27 October 2025

Re: Canterbury Bankstown City Council Submission to the State Significant Development Application, SSD-83256463 – 150 The Boulevard and 34 Dudley Street, Punchbowl, Punchbowl, Homes NSW Affordable Housing Development

Attachment A - Summary of Additional Information, Amendments and Recommended Conditions of Consent Requested by Council

Attachment B - Detailed Comments

Drawing number+ revision	A_SSDA_121	B
--------------------------	------------	---

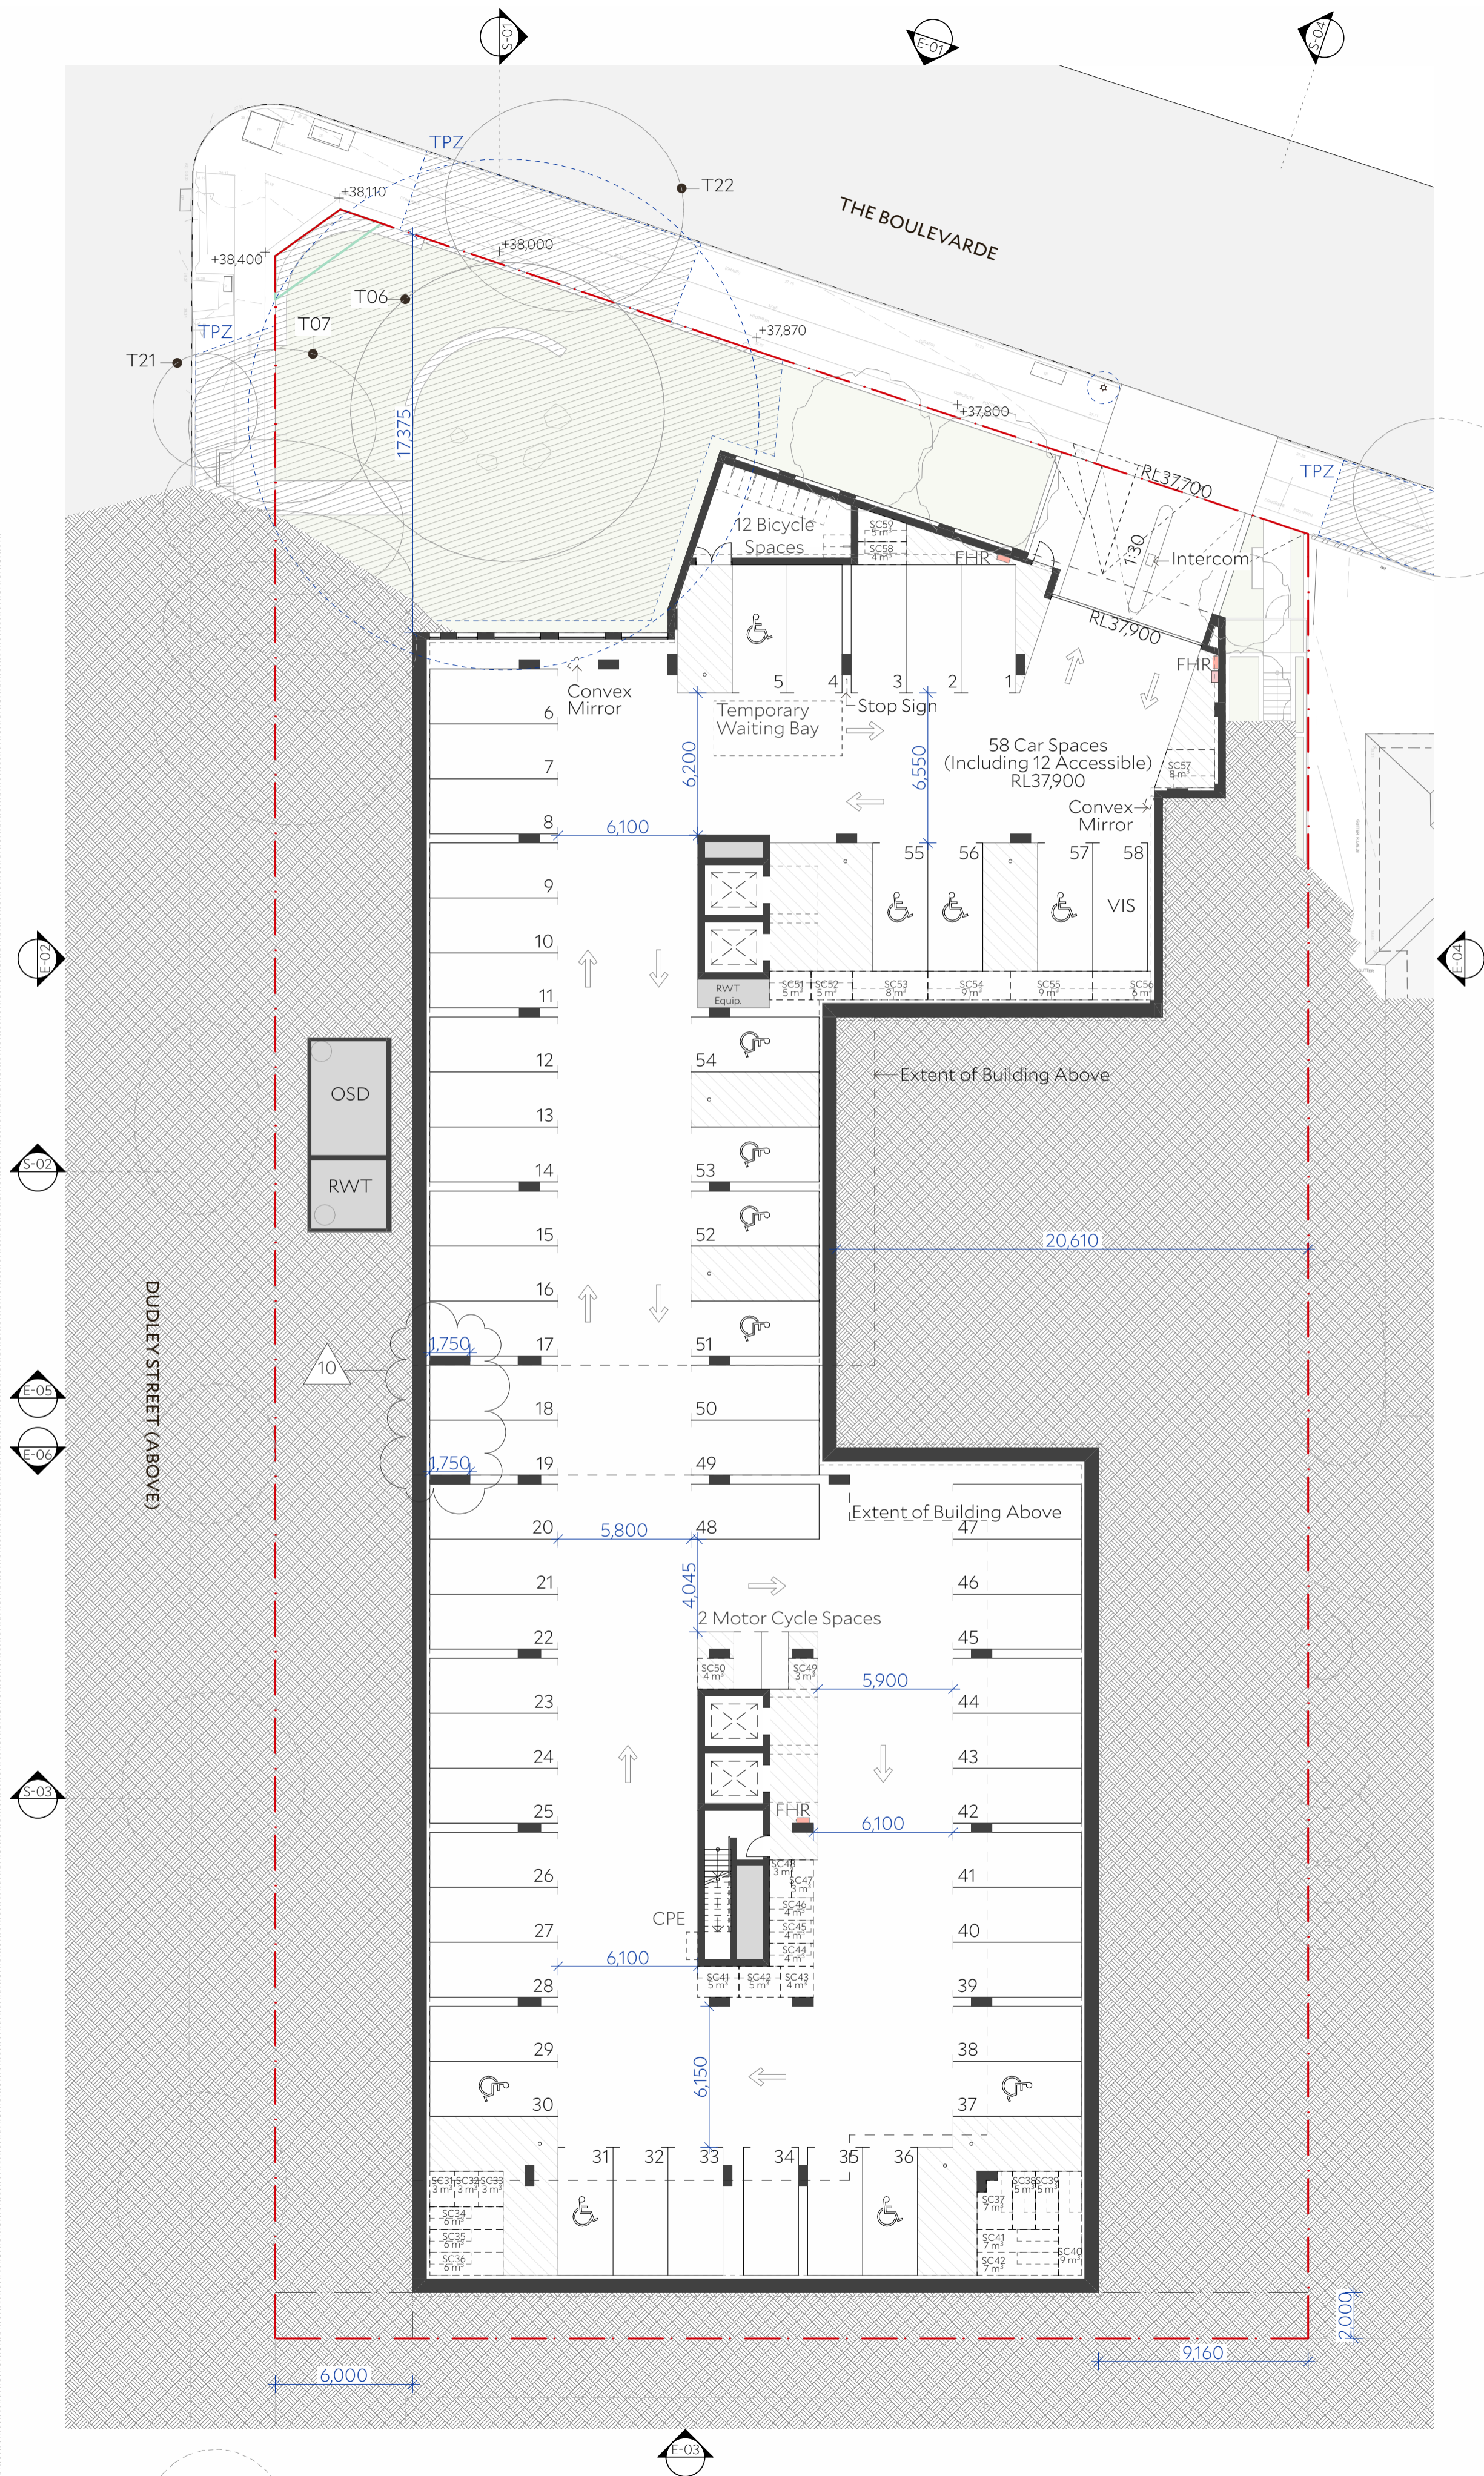
Category	Council Feedback
Engineering Services	Stormwater 1.1 The proposed design of the underground On-Site Detention (OSD) will not be supported with its current connection to the new inlet pit within Dudley Street, because proposed OSD storage will not be achieved as intended due to backwater effects, drowned orifice and dead storage. 1.2 The proposed design is intrusive requiring the installation of a new 375 Ø new concrete pipe (approximately 25m long along the kerb line within Dudley Street). The site enjoys a generous natural slope which provides an ideal platform for a less intrusive stormwater design following the natural slope, where stormwater can easily be discharged onto the kerb within The Boulevard without the need for a new street stormwater system along Dudley Street, this kind of design is reserved for difficult, restricted and flat site with hardly any slope, which is not the case for the subject site. <u>Recommendation:</u> It is strongly recommended that the stormwater drainage design should be prepared by an engineer with relevant hydraulic design experience. Basement car park 1.3 The location of structural column between spaces 17 & 18 and 19 & 20 do not comply with Figure 5.2 Design Envelope Around Parked Vehicles of AS2890.1 (as shown in below snippet).  1.4 The shared area next to dedicate space No. 31 is restricted with the structural column, this area shall be unobstructed for it to be a functional space (as shown in below snippet).

Drawing number+ revision	A_SSDA_201	B
--------------------------	------------	---

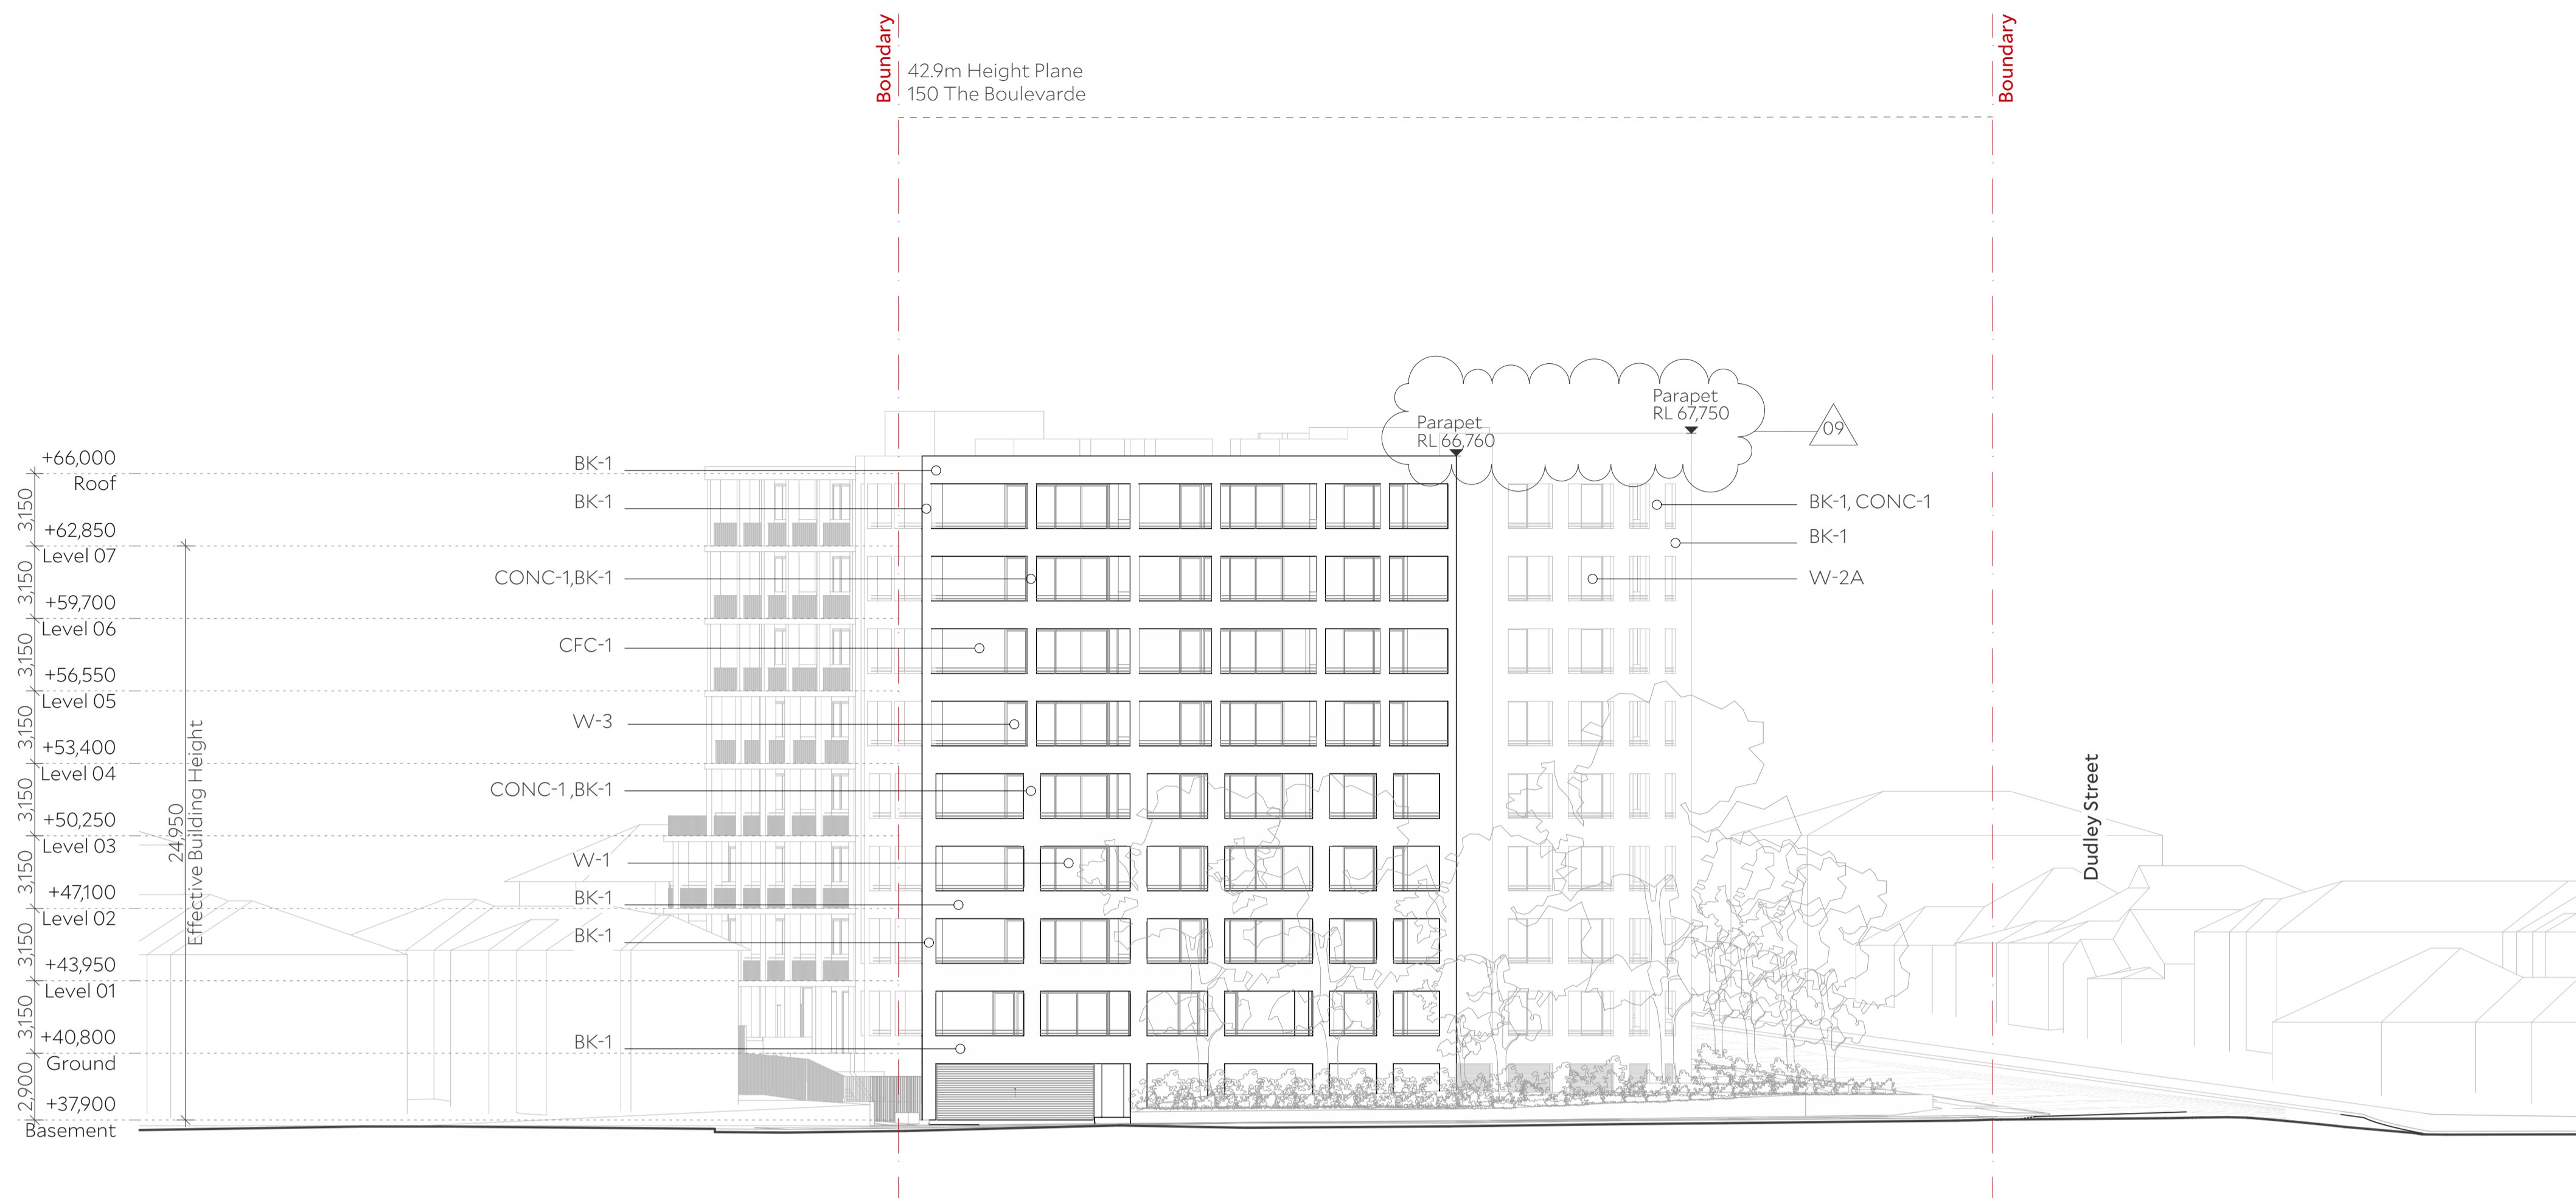
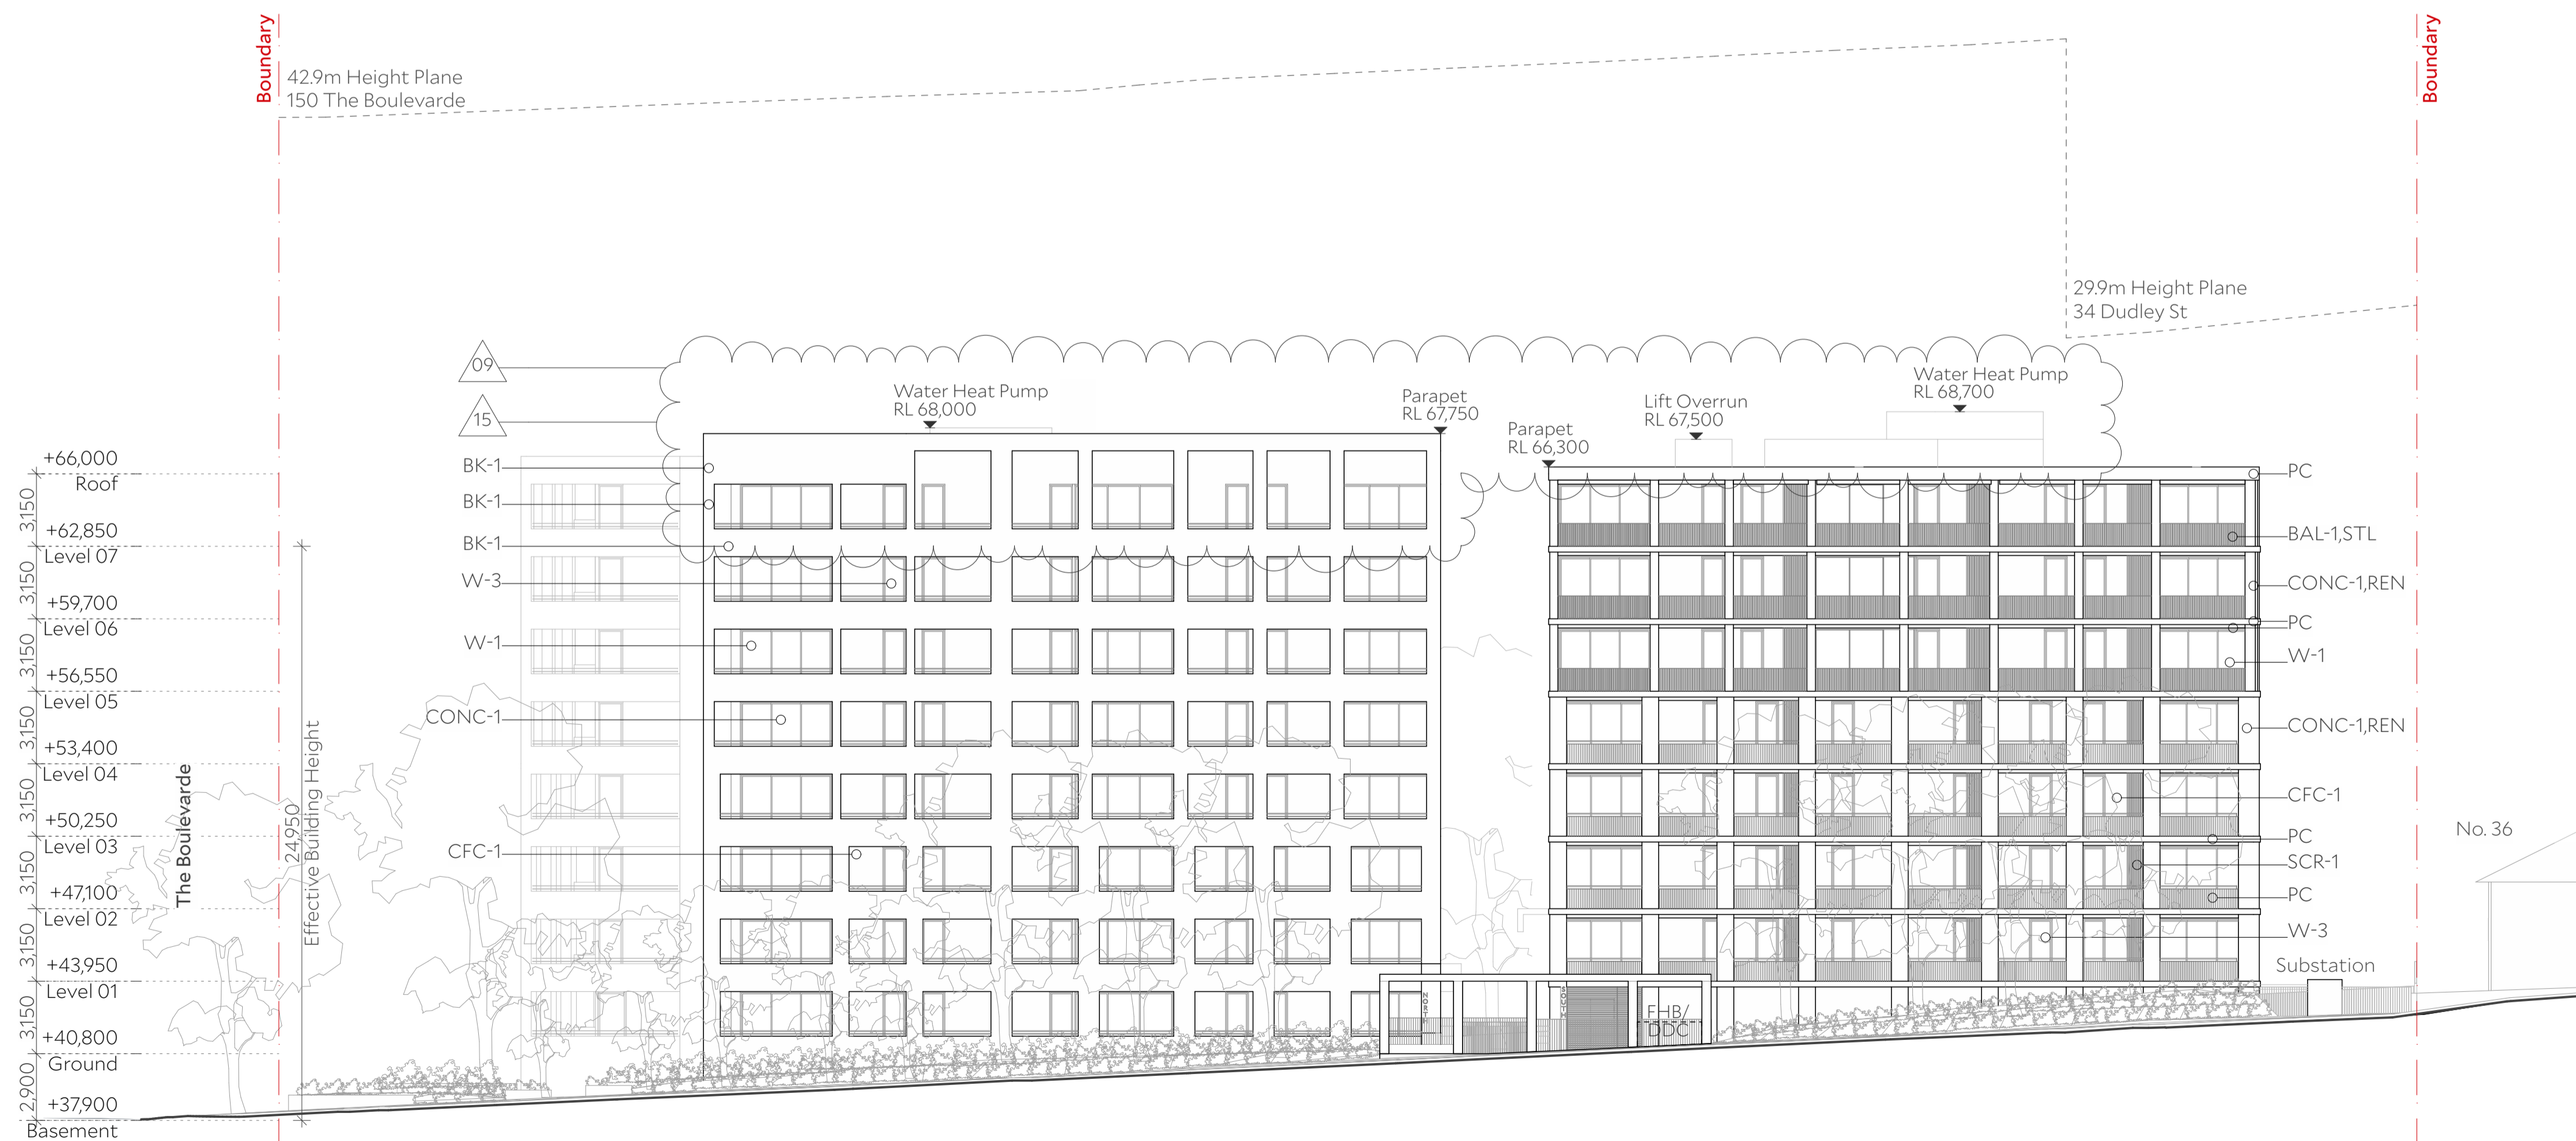
Category	Council Feedback
	<u>Recommendation:</u> The proposal should reconfigure this pathway to run parallel to the adjacent vehicular driveway, ensuring clear sightlines and a stronger visual connection with the street. 2.5 Several apartments (AG01,AG03, A101, A104, A201, A204, A301, A304, A401, A404, A501, A504, A601, A604, A701 and A704) include extended balcony portions of very narrow width that can barely accommodate seating or a small table, limiting their usability and functionality. In addition, some adjoining rooms have no access to these balconies, further limiting their accessibility and genuine usability. <u>Recommendation:</u> The proposal should adjust balcony widths and access points to enhance the overall quality and amenity of private open spaces. 2.6 Unit B104 presents an opportunity to strengthen façade alignment and improve private open-space amenity by extending its balcony southwards to align with the building's southern edge. <u>Recommendation:</u> This adjustment would create a more functional and proportionate outdoor area, enhance daylight penetration, and contribute to a more consistent façade composition along the southern elevation. 2.7 The proposed waste management arrangements require the bins from Building A to be transferred through the main residential corridor at ground level to the collection room in Building B, creating potential conflicts with resident circulation and compromising the amenity of the ground floor spaces on the collection day. <u>Recommendation:</u> The proposal should nominate an alternative route, preferably via the basement levels or a dedicated service corridor at the rear, to avoid conflicts and ensure an adequate level of amenity. Façade design and articulation 3.1 The façades of Building A, along The Boulevard and Dudley Street exhibit excessive vertical and horizontal modulation, resulting in a visually busy yet monotonous expression. The composition lacks variety, material richness, and hierarchy, giving the façade a repetitive, formal appearance. <u>Recommendation:</u> There is an opportunity to simplify the articulation and introduce greater material diversity, depth, and contrast to create visual interest and a more distinctive architectural character that better reflects the desired street identity. These refinements should align with the emerging street-wall height and desired future character (refer to 1.3), ensuring that the lower levels present a human-scale rhythm, and the upper levels are visually lightened through recesses or tonal contrast Refer to the images below for further reference.
